CITY OF ALBUQUERQUE

December 27, 2023

**RE: MDS - Montage Subdivision Unit 7 on Bobby Foster
Grading and Drainage Submittal for Preliminary Plat and Grading Permit
Grading Plan Engineer's Stamp Date: 8/16/2023
Hydrology File: R16D100A**

TITLE: STORMCAD PLAN VIEW MONTAGE 7 - MESA DEL SOL			
Design Review Committee	City Engineer	Mo./Day/Yr.	
City Project No.	Zone Map No.	Sheet	
		OF	
		EXHIBIT 3

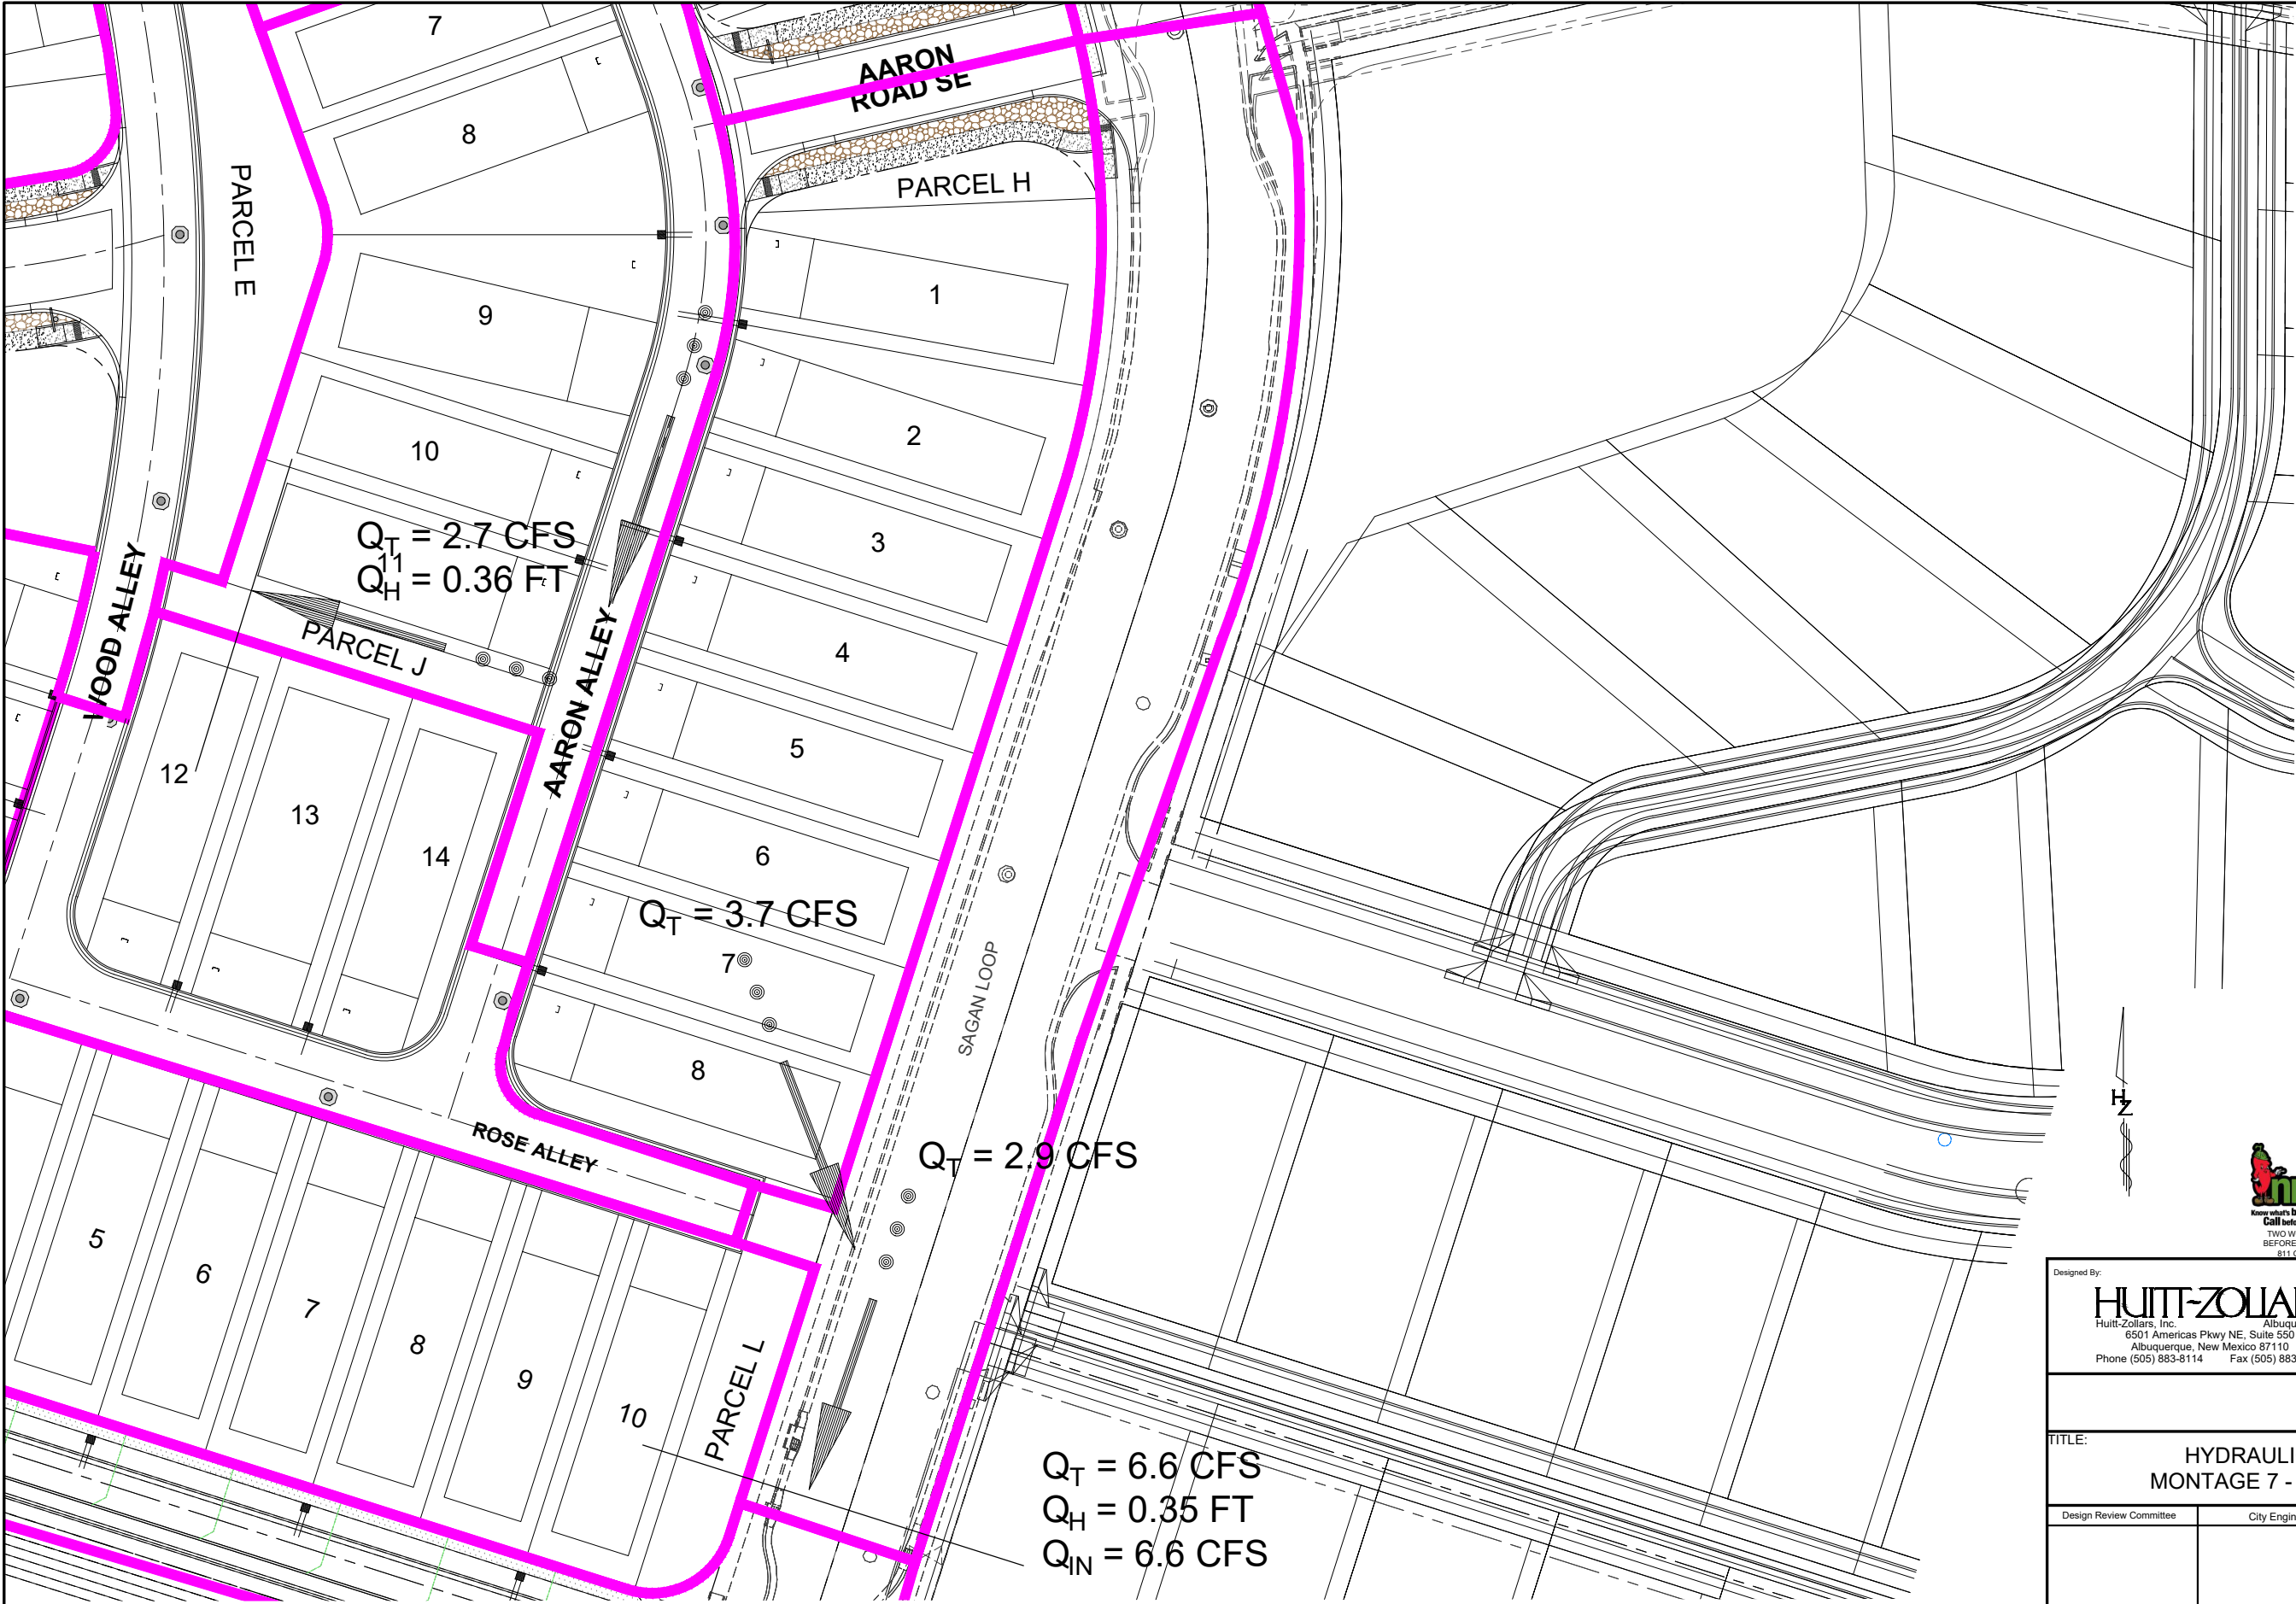
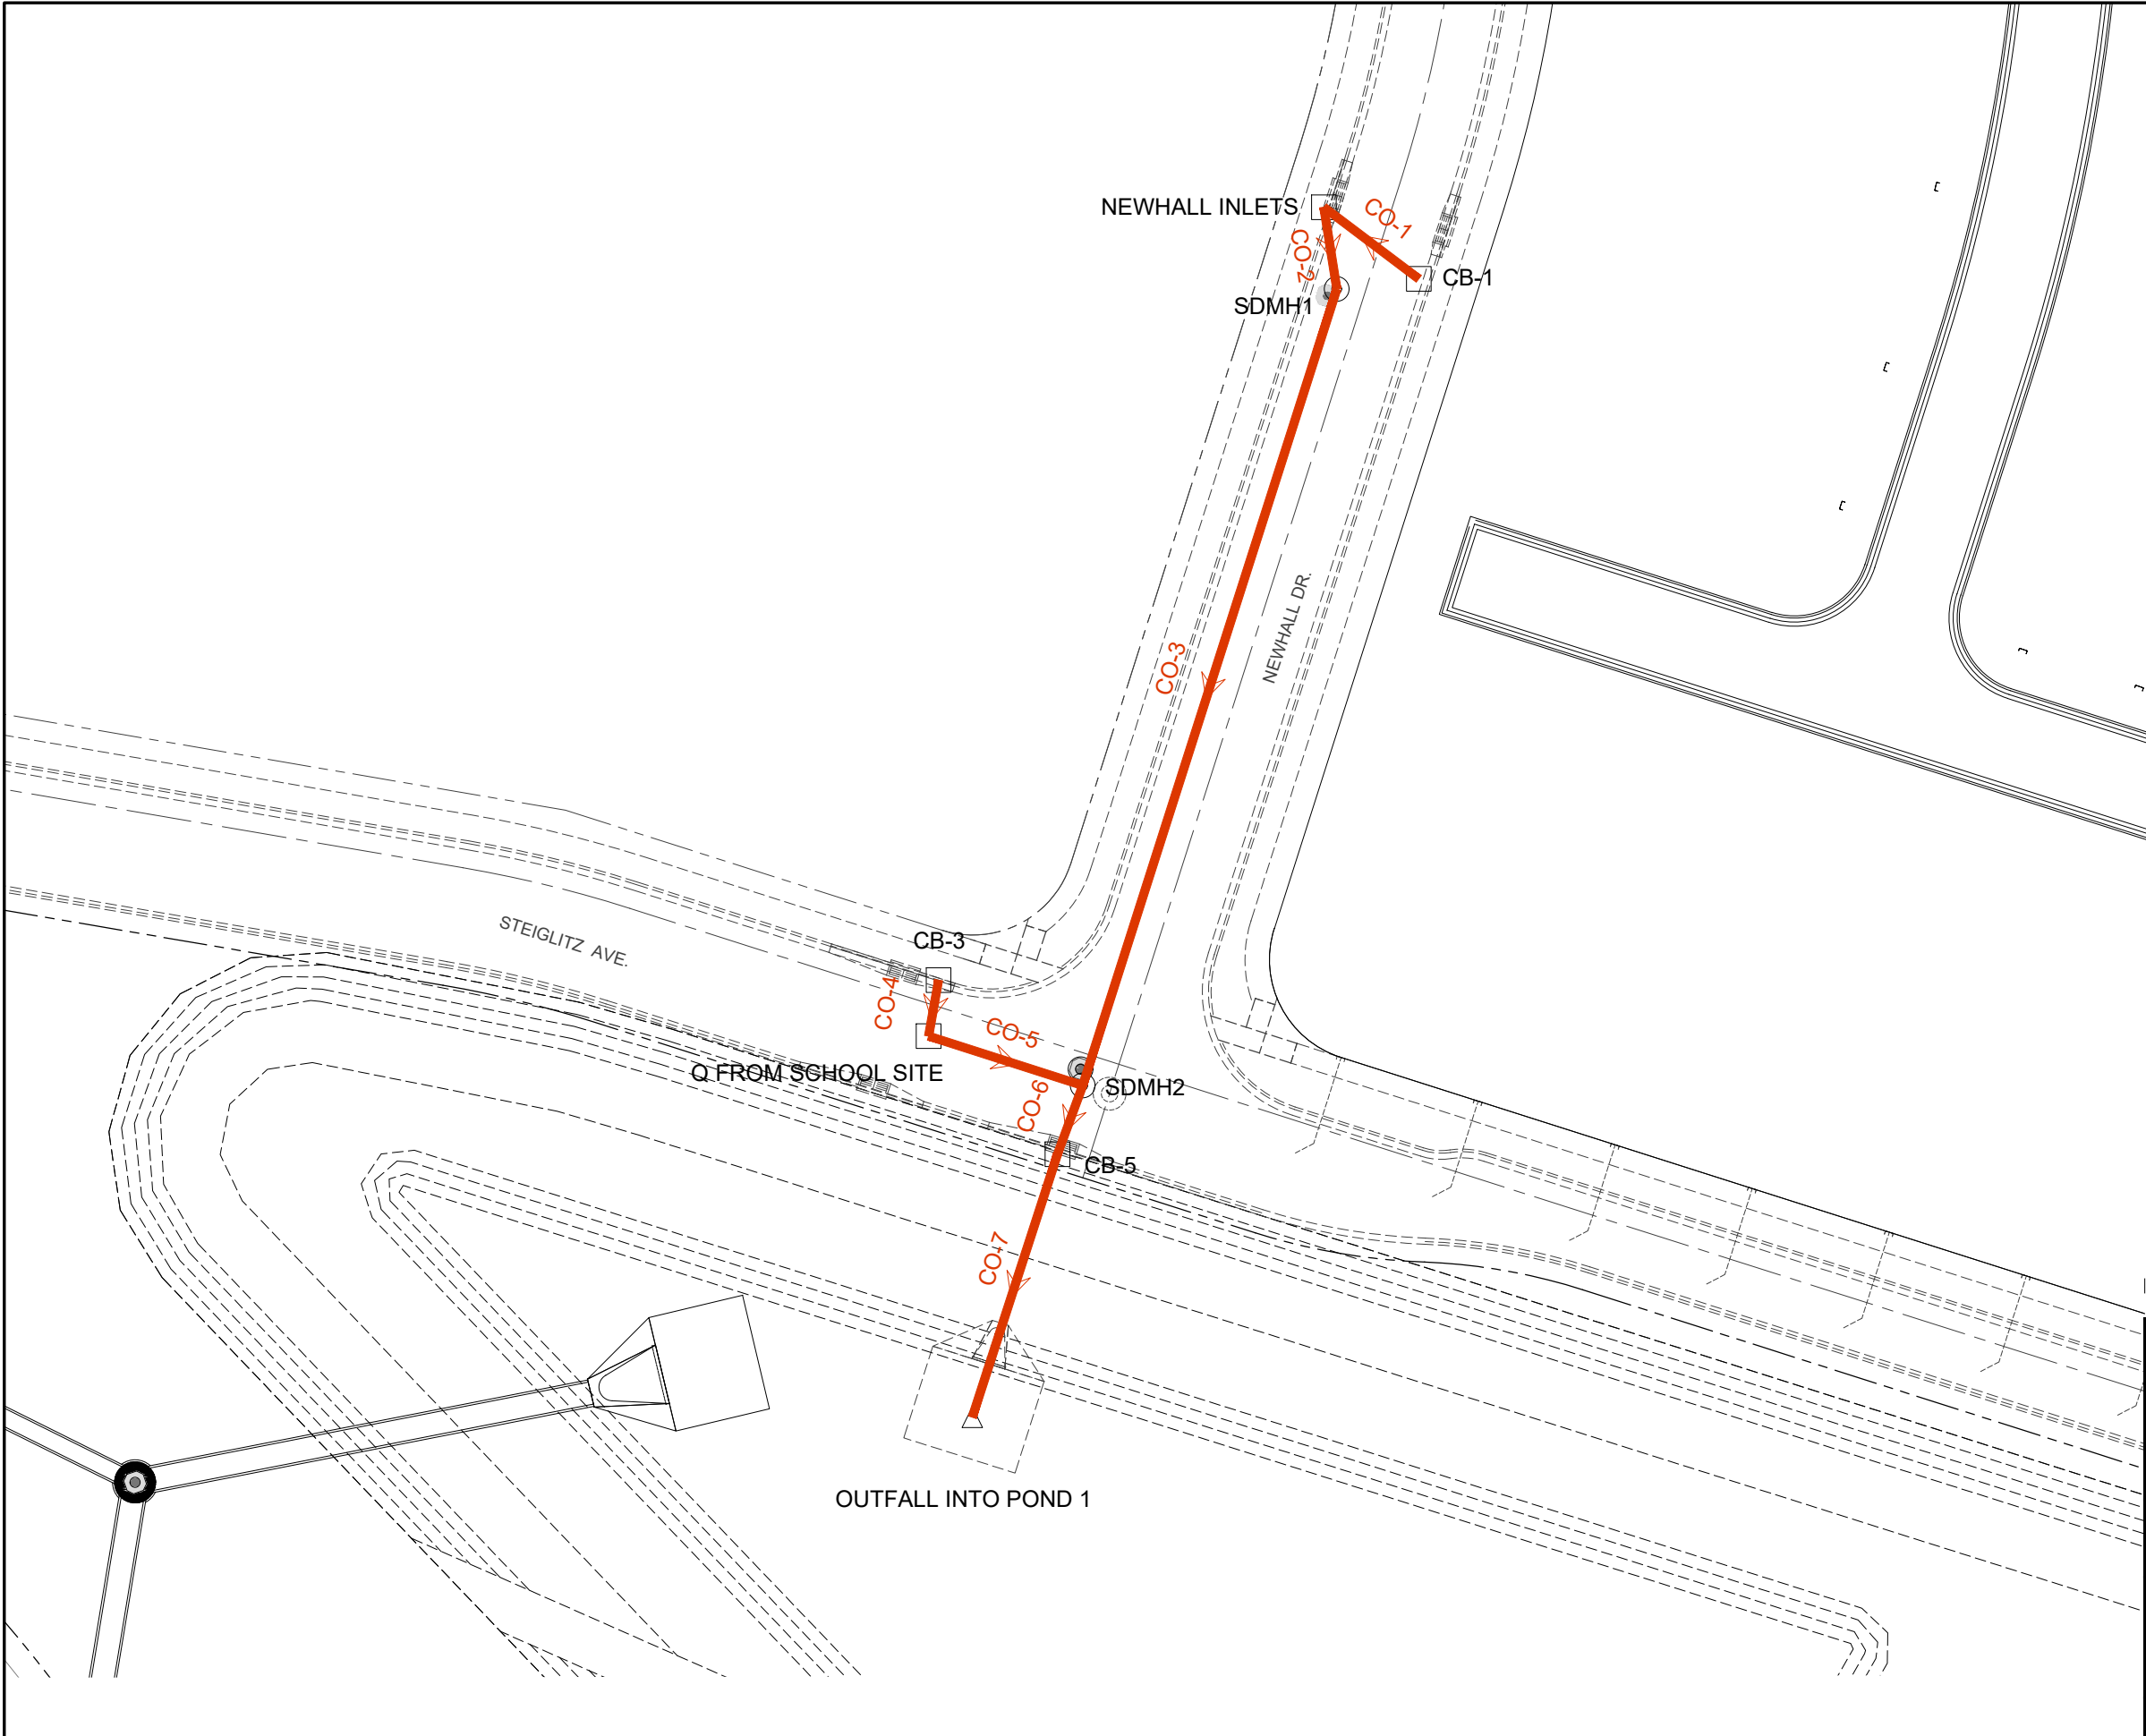
1. Please provide sub-basin map. I do need this map with basins' acreages to verify your calculations.
